Your Reference
SSD-83256478

**Beauchamp Road, Hillsdale, Affordable Housing — Response
to Submissions RFI #2**

Our Reference
703103419-009

THIS PLAN IS TO BE READ IN CONJUNCTION WITH THE LATEST ARCHITECTURAL PLANS AND STRUCTURAL ENGINEERS PLANS FOR DETAILS.

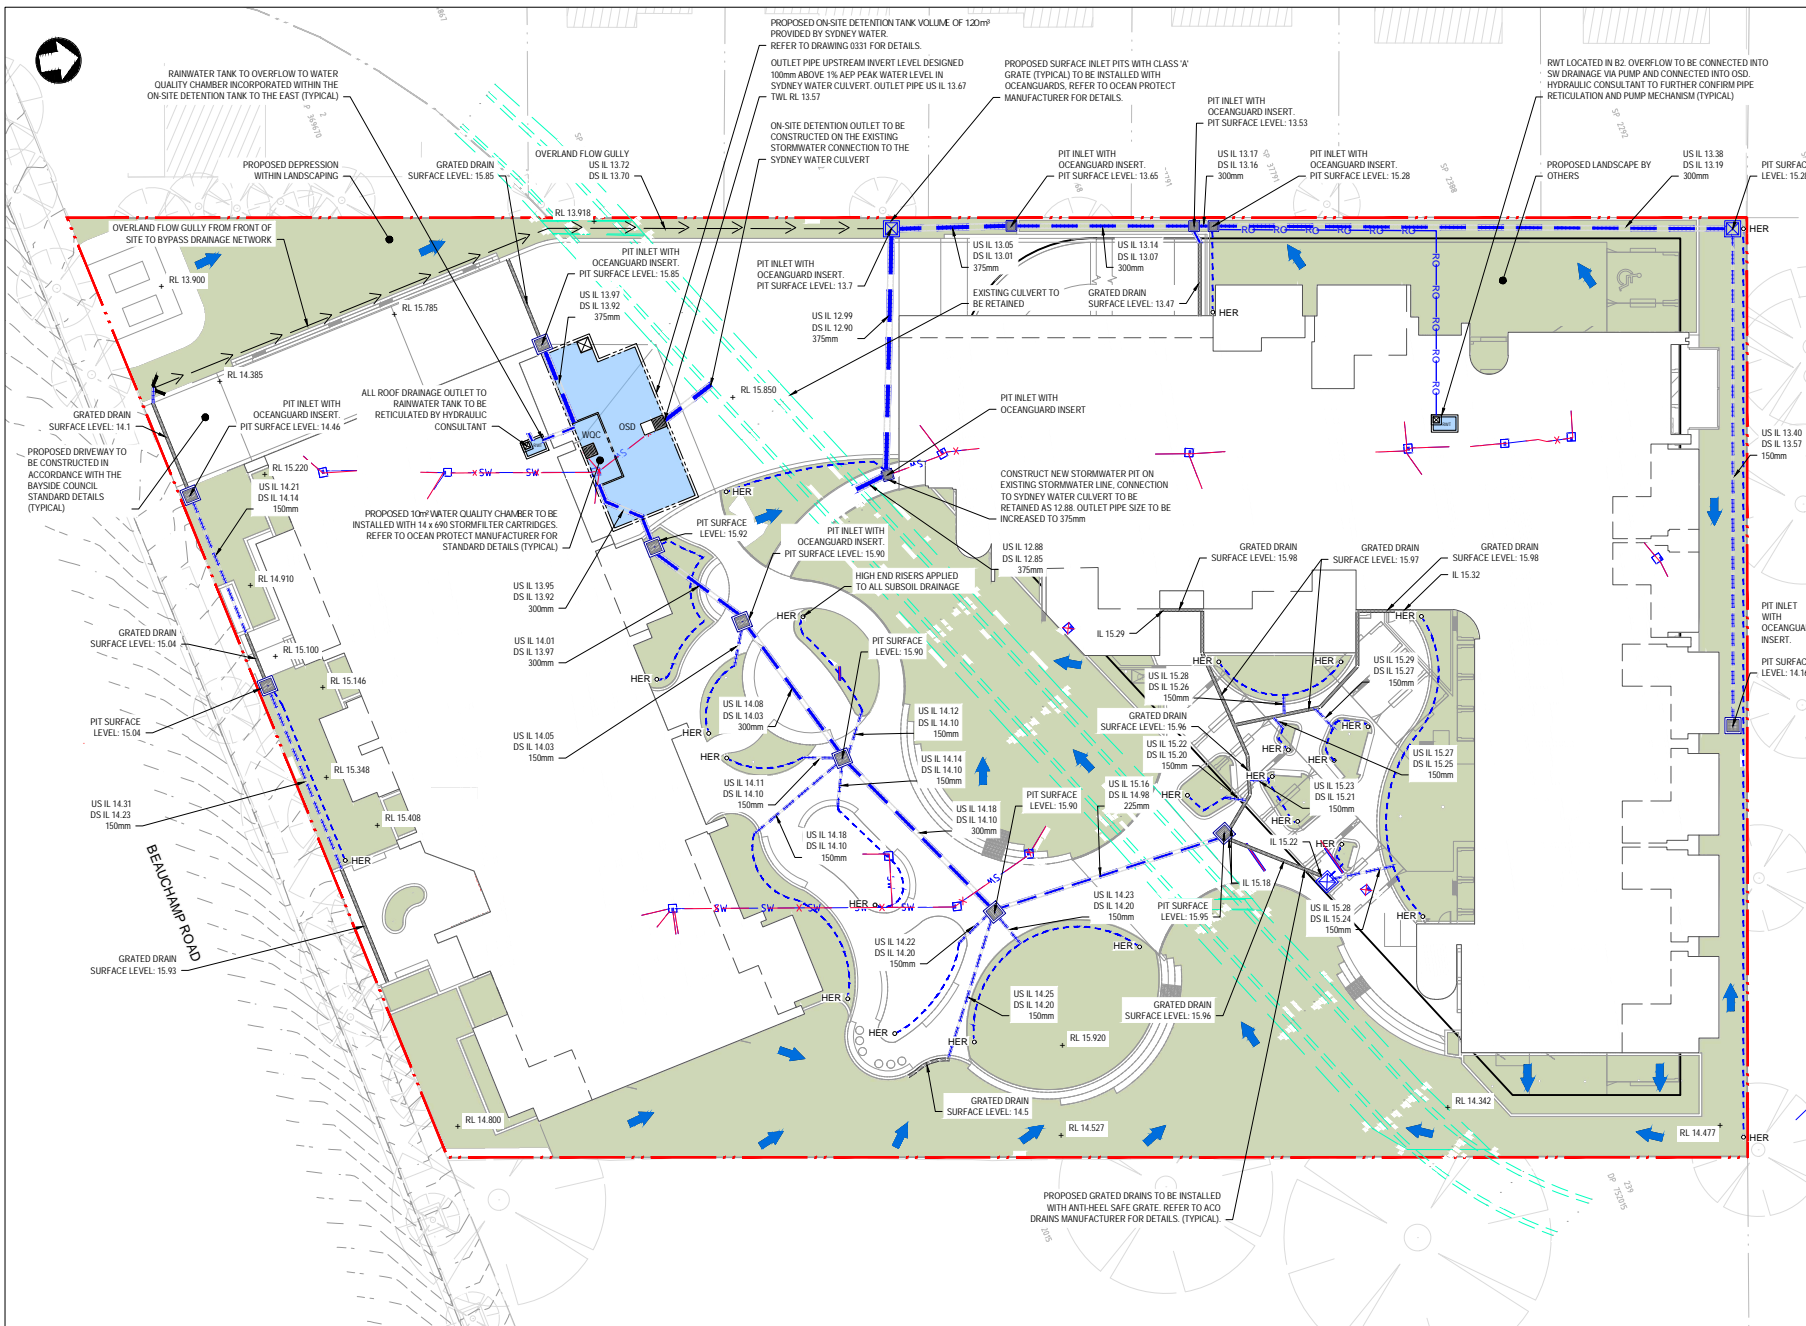
"Please provide revised cut and fill plans that accurately detail cut and fill works proposed. The current plans show fill proposed along the drainage channel."

2	The cut & fill plan indicates significant fill across the overland flow path which is not acceptable. The plan also appears to be incorrect given the presence of fill where there are two bridges spanning over the flow path. The cut & fill plan needs revision.	The bulk earthworks strategy has been revised to accurately reflect the agreed approach with Sydney Water, which avoids placement of fill over the existing culvert and drainage channel. The updated design ensures that existing hydraulic capacity and functionality of the drainage overland flow path is maintained. To achieve this outcome, the design incorporates suspended structural elements, including a suspended driveway slab and a suspended pedestrian bridge, located over the drainage corridor. These elements eliminate the need for fill within sensitive drainage areas while maintaining site accessibility and functionality. Detailed structural design of these suspended elements will be undertaken during the Construction Certificate stage to ensure compliance with relevant standards and coordination with the civil design intent. The revised cut and fill arrangements are shown in the updated Civil Engineering Drawing Set, Revision P4, dated 14/05/2026 and the Integrated Water Management Plan, Rev [D] submitted for review.

The bulk earthworks strategy has been revised to more accurately reflect the agreed approach with Sydney Water, which avoids placement of fill over the existing culvert and drainage channel. The updated design ensures that existing hydraulic capacity and functionality of the drainage overland flow path is maintained.

To achieve this outcome, the design incorporates suspended structural elements, including a suspended driveway slab and a suspended pedestrian bridge, located over the drainage corridor. These elements eliminate the need for fill within sensitive drainage areas while maintaining site accessibility and functionality.

The revised cut and fill arrangements are shown in the updated Civil Engineering Drawing Set, Revision P4, dated 14/05/2026 and the Integrated Water Management Plan, Rev [D] submitted alongside this letter.
